MECKLENBURG COUNTY
Park and Recreation Department

MEMORANDUM

DATE: April 17, 2008

RE: Rezoning Petition # 2008-083 (PID #s 083-021-01 and 083-031-15)

MATHESON AVENUE/30th STREET
 COLLEGE STREET EXT. AND DRIVEWAY ACCESS PLAN
TECHNICAL DATA SHEET NOTES

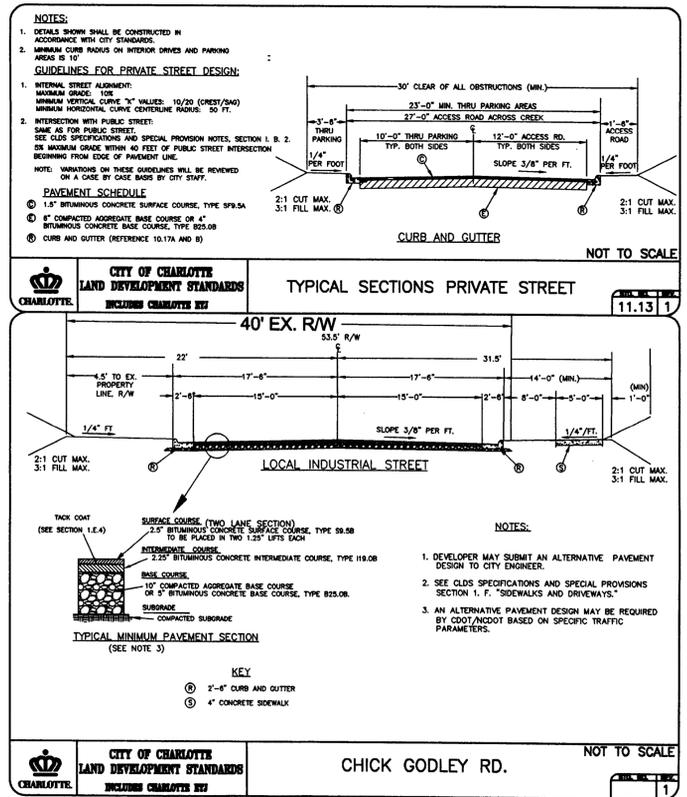
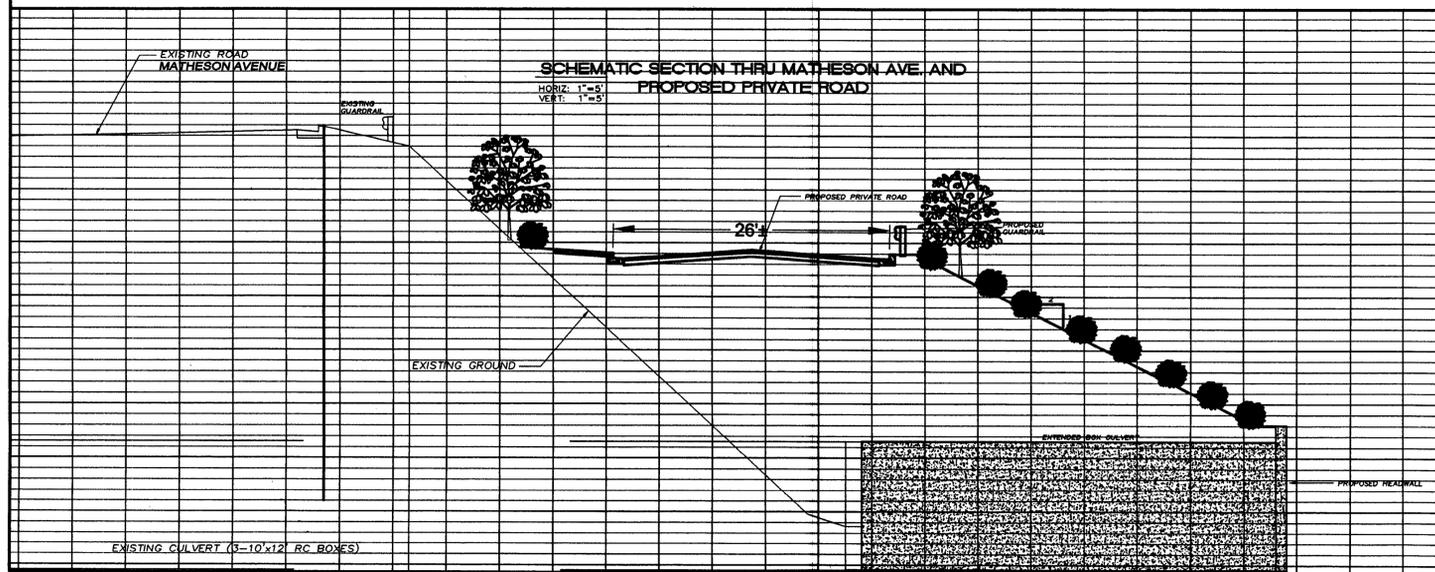
On the Technical Data Sheet Notes and Illustrative Site Plan the petitioner has stated that they will dedicate the "SWIM buffer plus 50% of the FEMA floodway". MCPR is appreciative of the dedication. However, we request that the notes state that "Dedication of the greenway to Mecklenburg County Park and Recreation shall be upon the first certificate of occupancy issued for the site. The Greenway dedication shall encompass the 100' SWIM buffer plus 50% of the FEMA floodway. The Greenway dedication area shall not include any areas required for water quality measures installed within the floodway, nor shall it include any open or common space areas required to meet the development standards. All water quality measures shall be located outside of the 100' SWIM buffer."

MATHESON AVENUE/30th STREET
 COLLEGE STREET EXT. AND DRIVEWAY ACCESS PLAN
 ILLUSTRATIVE SITE PLAN

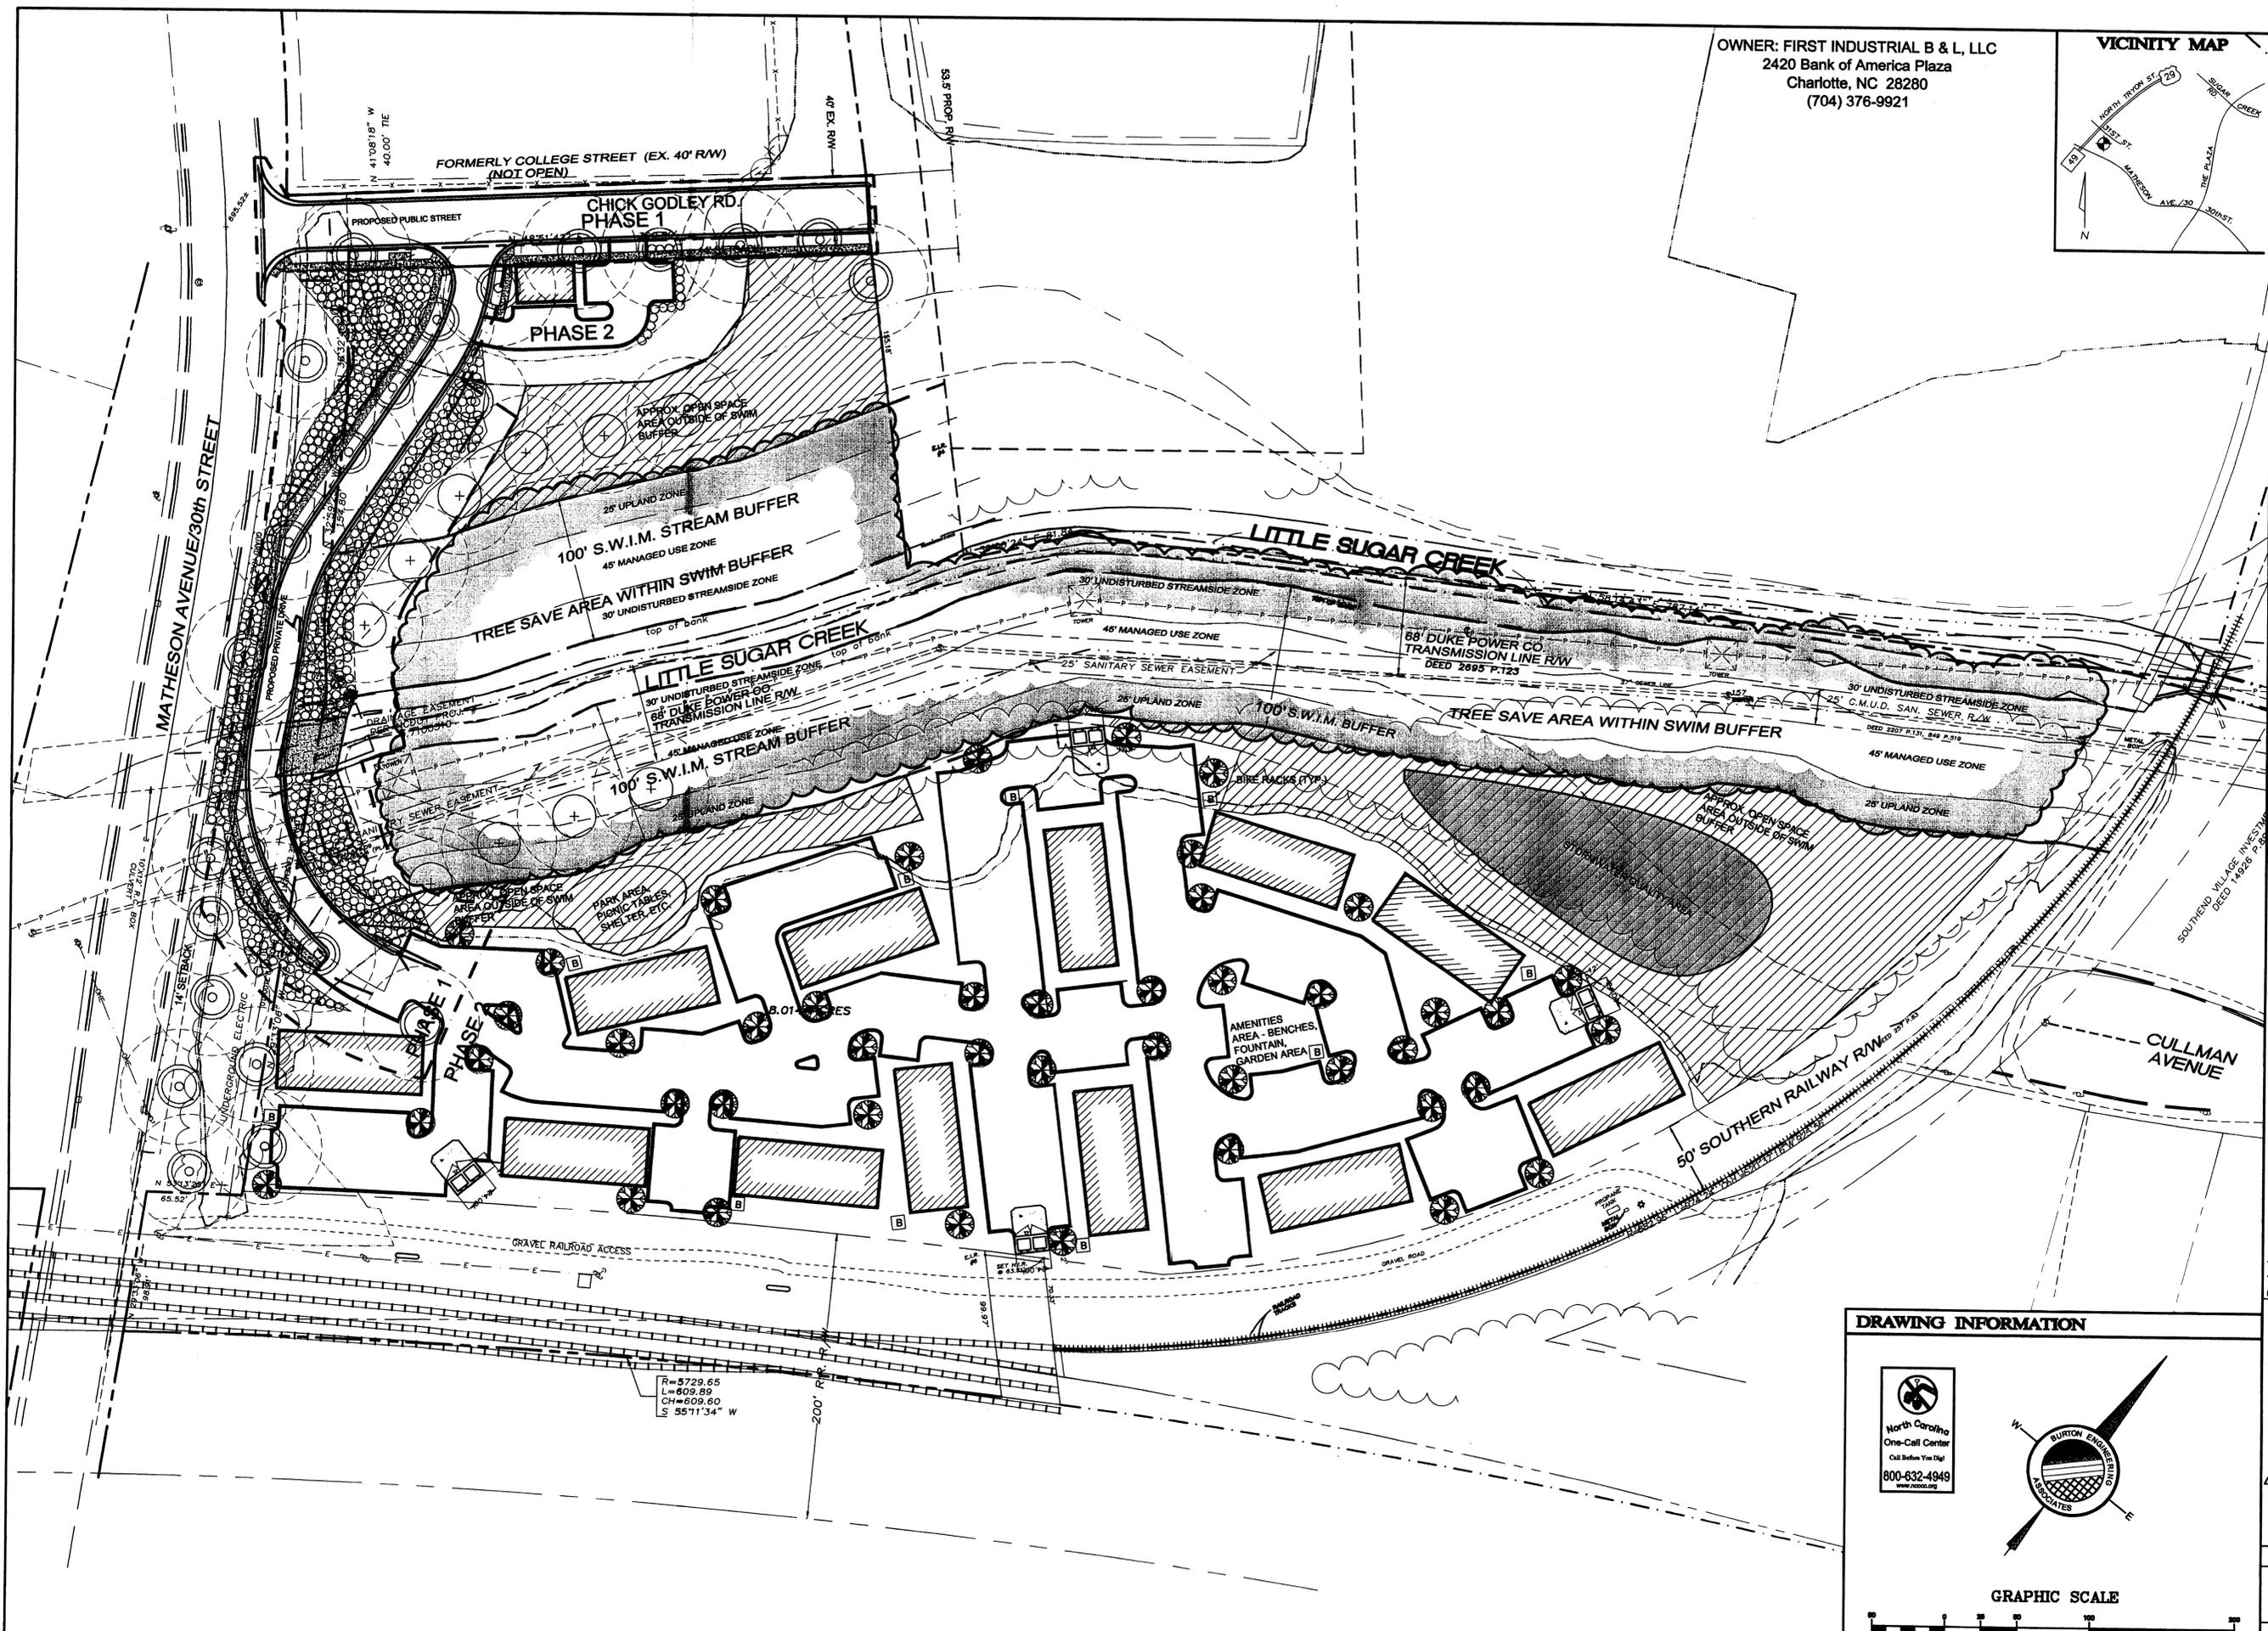
MCPR encourages the development of a pedestrian path between buildings #6 and 7 (as shown

on the Illustrative Site Plan) to Cullman Ave. following the existing gravel access road. MCPR also encourages an interior sidewalk system to make the development more pedestrian friendly.
